From: simon harvey [REDACTED]
Sent: 05 June 2019 00:16
To: Zac Denton <Zac.Denton@arun.gov.uk>
Cc: Conservation Officer <Conservation.Officer@arun.gov.uk>
Subject: Re: LY/4/19/HH - Extension of Time

Thankyou for your email regarding the application at 253 Church Lane Lyminster.

“LY/4/19/HH

Drawing Title: PROPOSED ELEVATIONS

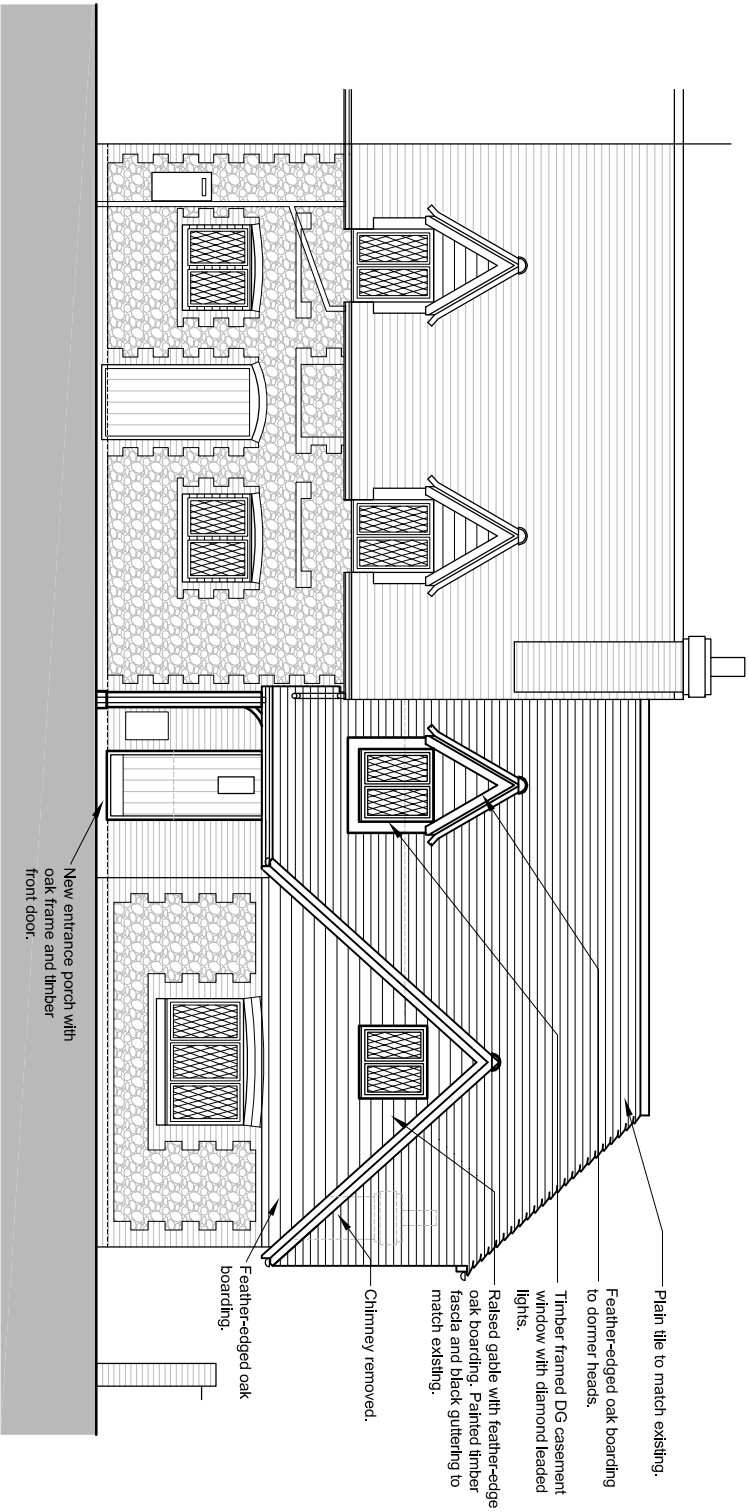
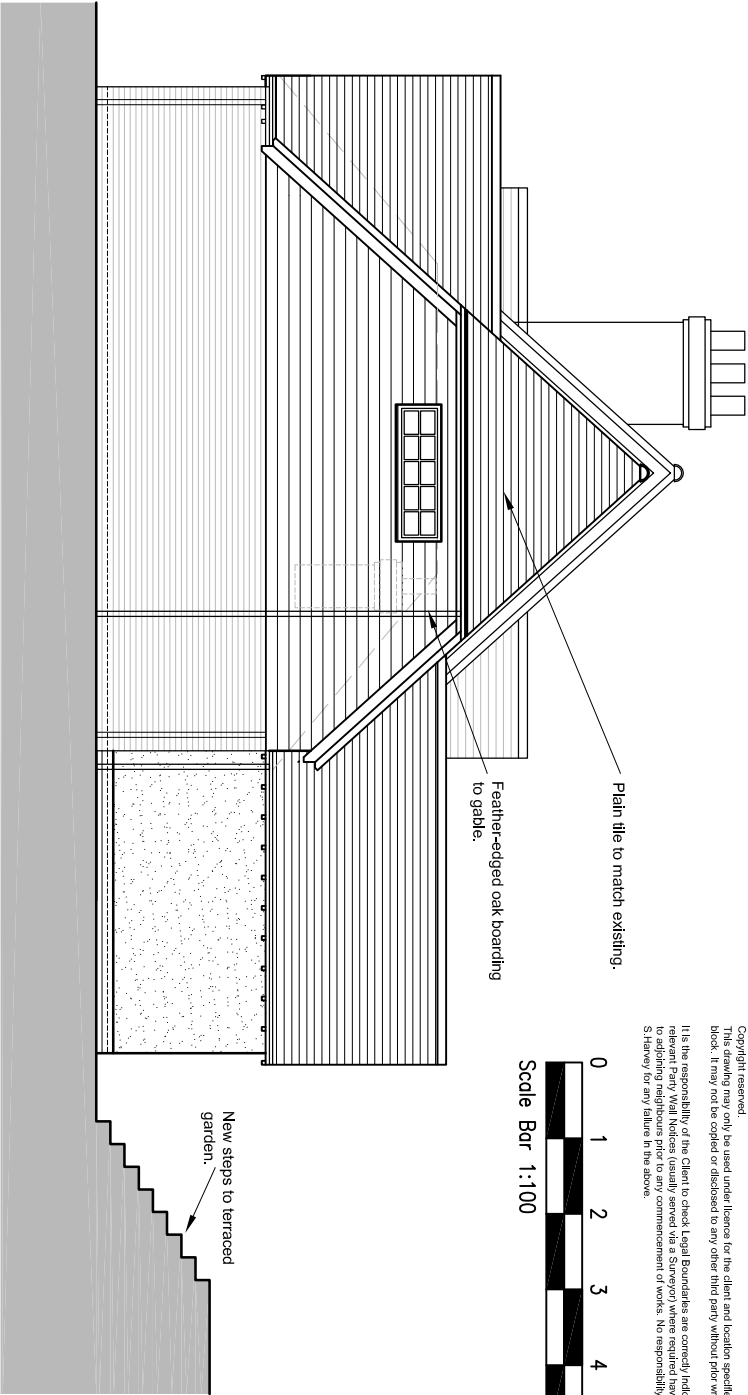
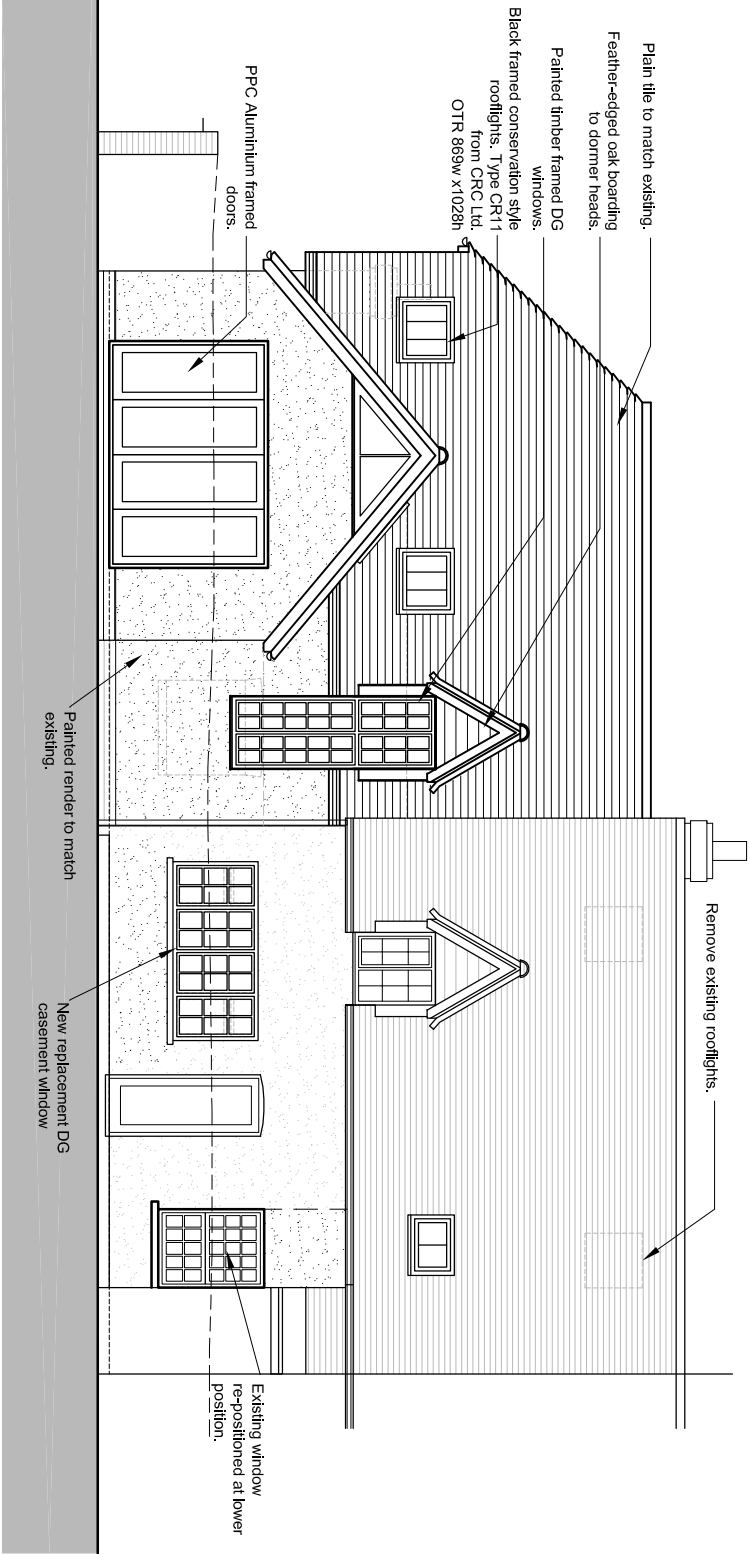
Although saying that, the loss of the chimney is unfortunate as it is visible from the lane.

The overall scale of the development is substantial and would be of a size as to make this part of the property (i.e. the modern extension and new works) appear larger than the existing, original cottage. It is considered that the new roof would appear to be larger than that of the existing cottage, and therefore not subservient to the host dwelling. It would therefore have an overbearing impact, which it is considered would dominate the street-scape and be out of keeping with the character of both the host dwelling and the immediate area.

It would also look like a separate unit of accommodation has been created, forming a fourth unit to the terrace, as opposed to a subservient extension to an existing property.

It is also not clear why a half hip has been proposed, when the existing two storey elements of the terrace have gabled elevations. This feature is repeated elsewhere in the conservation area.

The first floor extension has been substantially scaled back to both accentuate the visual gap between the neighbouring property and to ensure the width does not dominate the original frontage of the cottage, thus remaining subservient to the host dwelling. We hope that you will agree that we have worked sensitively to ensure that it is not overbearing on the street scene or indeed the host property. The half hip single storey element takes its form from surrounding vernacular including the gables of the cottages adjacent, whilst overcoming conflicting roof angles presented in the existing structure. As recommended, we have maintained a gabled end to follow the historic pattern of the host property. The chimney can also be retained as a feature of interest in the street scene.

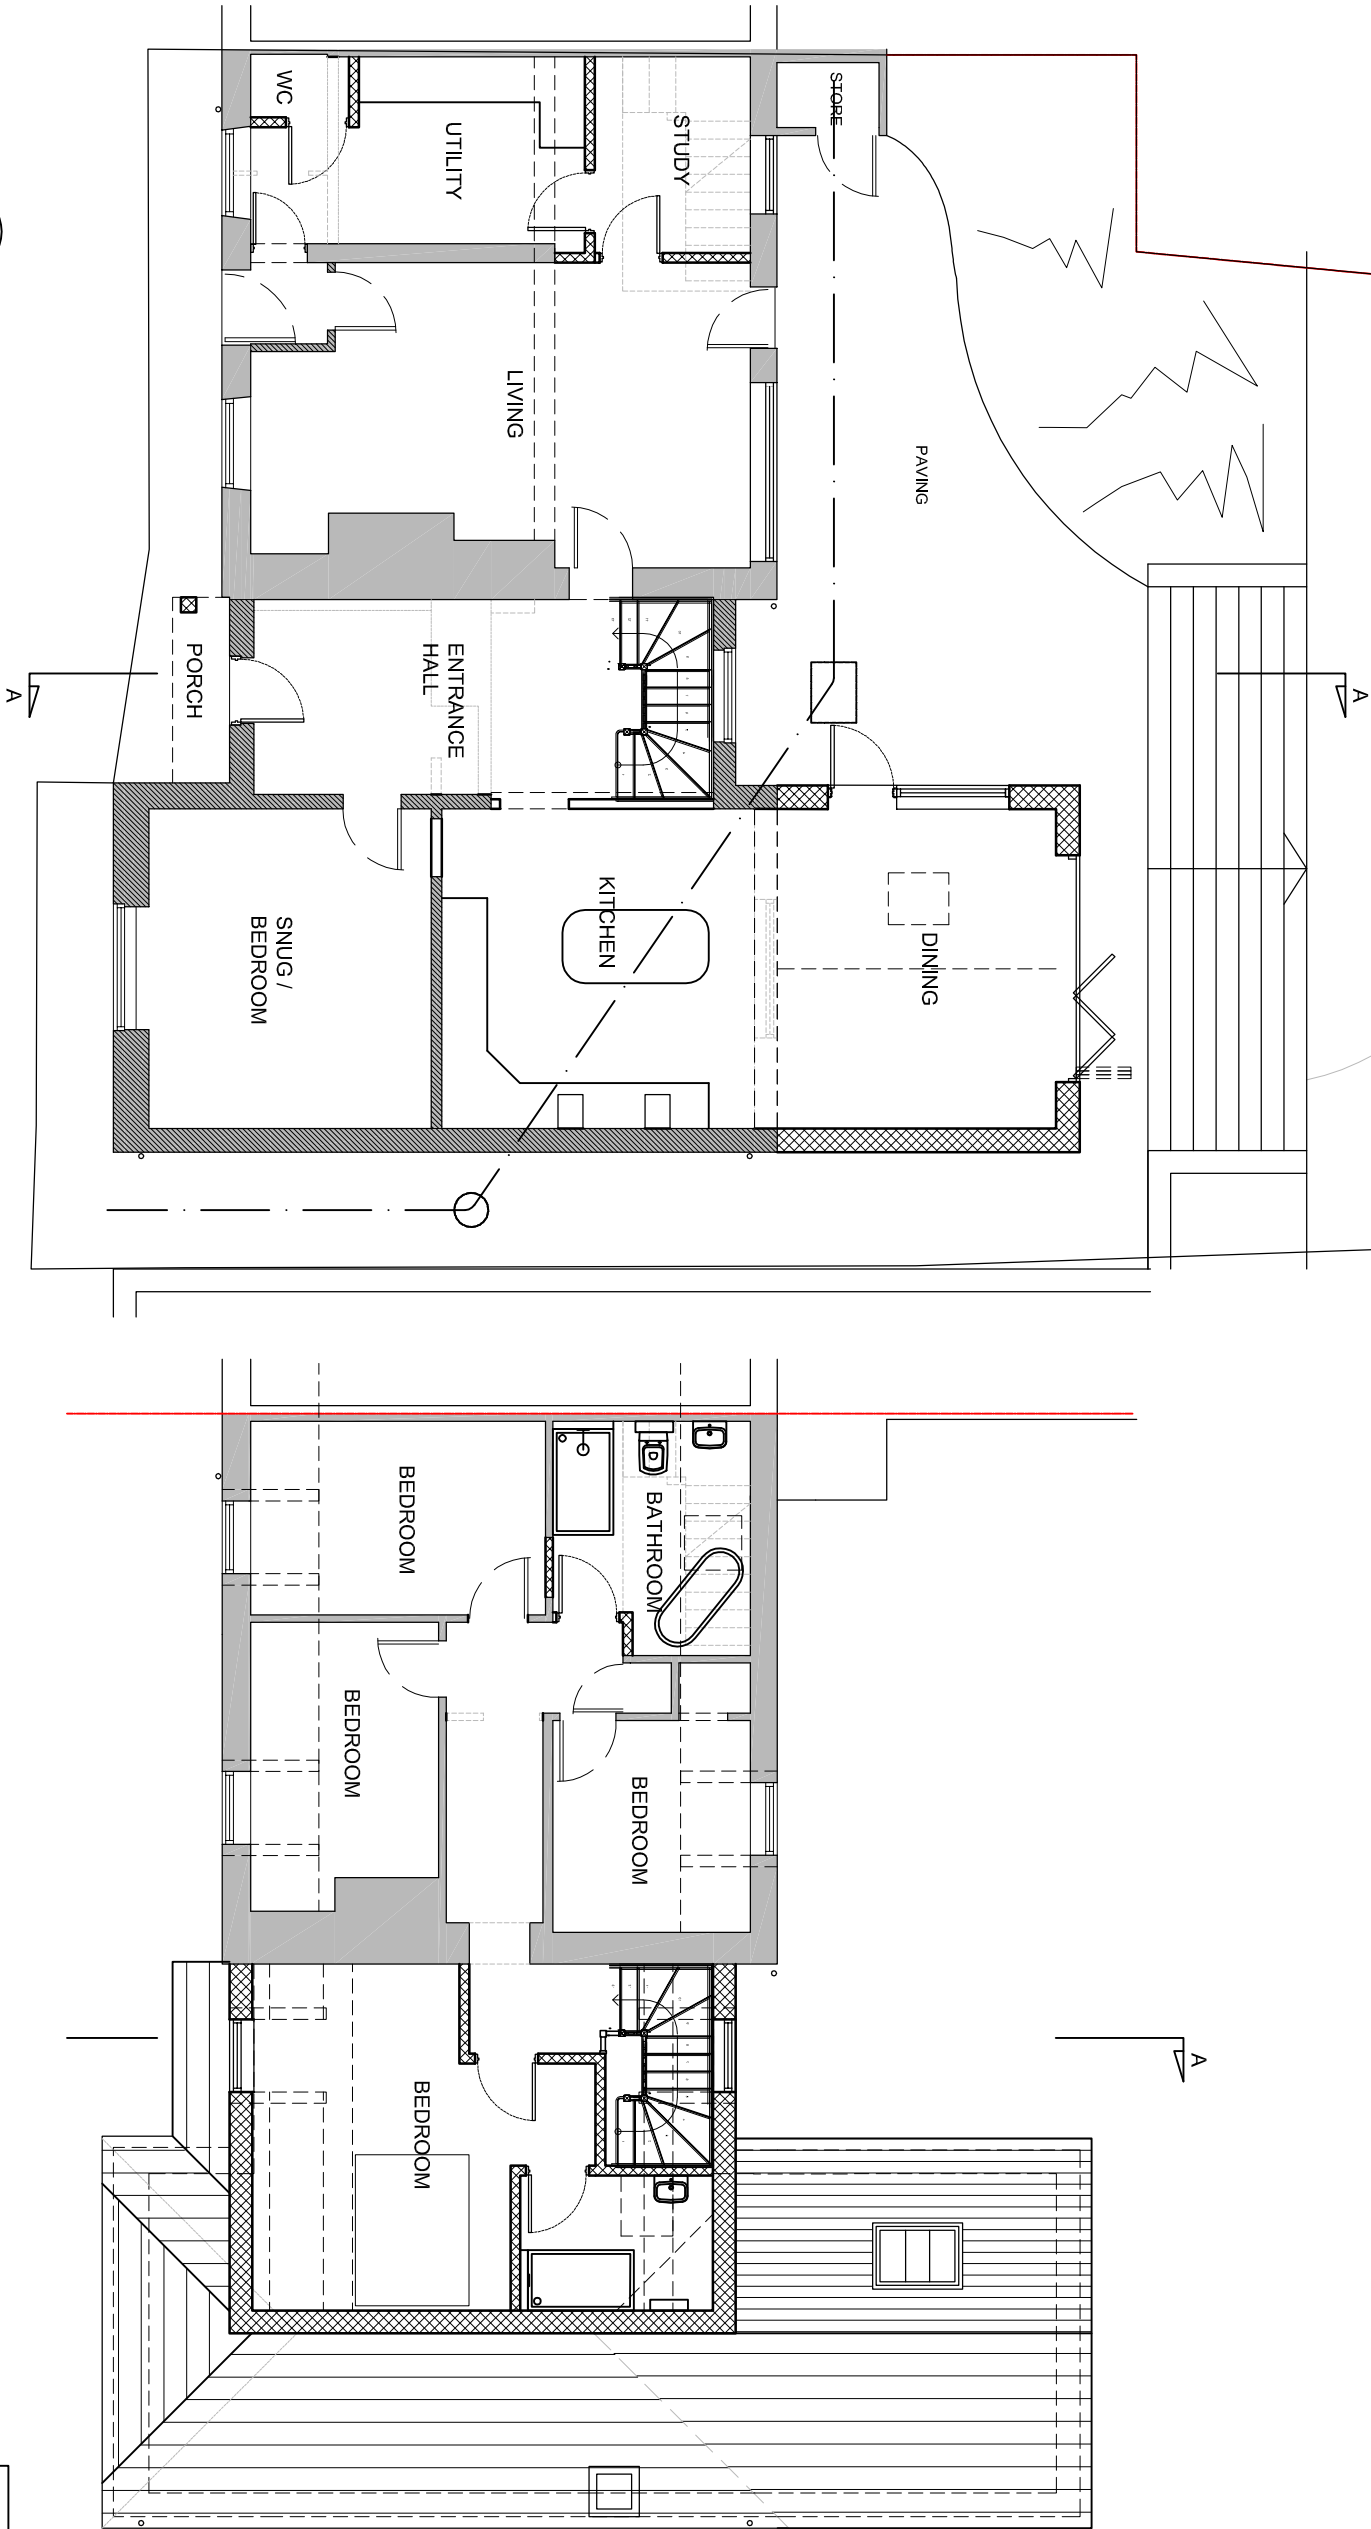
The single storey rear extension would be an addition to the modern part of the property, and of a scale which would mean that it could remain subservient to the host dwelling. Further, it would not be visible from the lane which would mean that it would not harm the character or appearance of the conservation area. The success of this element of the proposal would be dependent upon the quality of the materials and joinery to be used.

A positive feature of the proposal is the replacement rear casement window with something more in keeping with the property, along with the loss of the two upper level rooflights.
